From: Sue Howell <Sue.Howell@arun.gov.uk>
Sent: 04 October 2021 16:21
To: Simon Davis <Simon.Davis@arun.gov.uk>
Subject: RE: Drove Lane, Yapton (Y/49/21/RES) - Comments

Ok so I've tried to see where the differences lie in relation to my comments of 27 May 2021 below.

These would form the main comments that I would want to advise in relation to the revision G dwgs issued.

Geocellular Storage Below Detention Basin Pond 7 / SA25, Pond 8 / SA15, Pond 9 / SA23

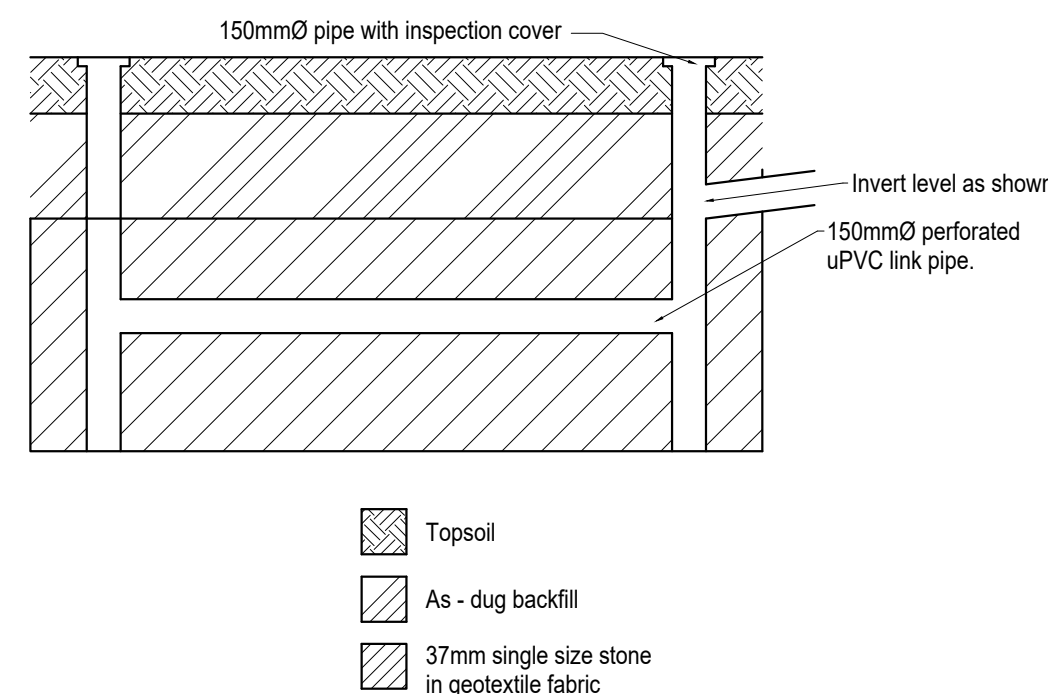
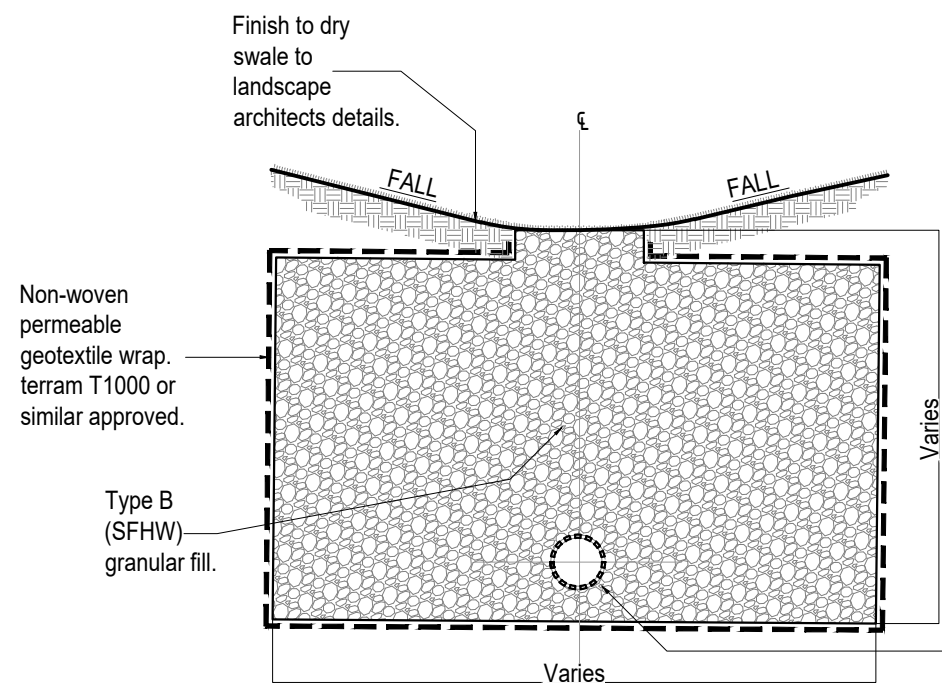
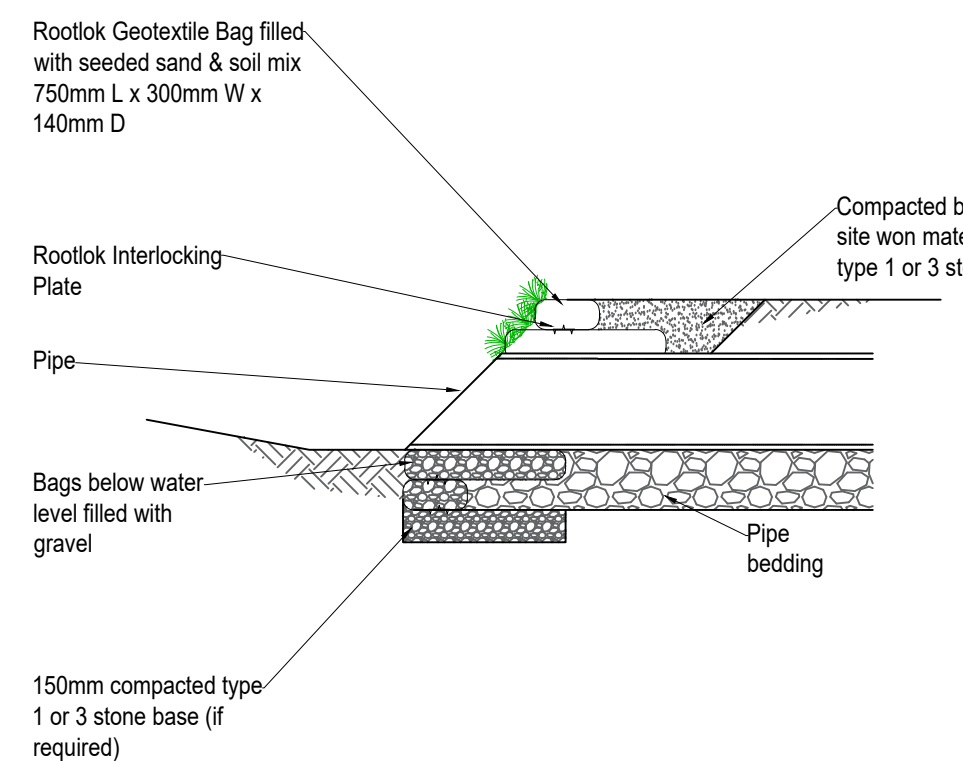
advocate the use of SuDS features for children's play as what could be a dry feature one day could potentially be a serious hazard another due to weather conditions and the potential for standing water. I would stress again that the **SuDS features including basins and swales in POS areas are ROSPA certified and not advertised or incorporated as play features.**
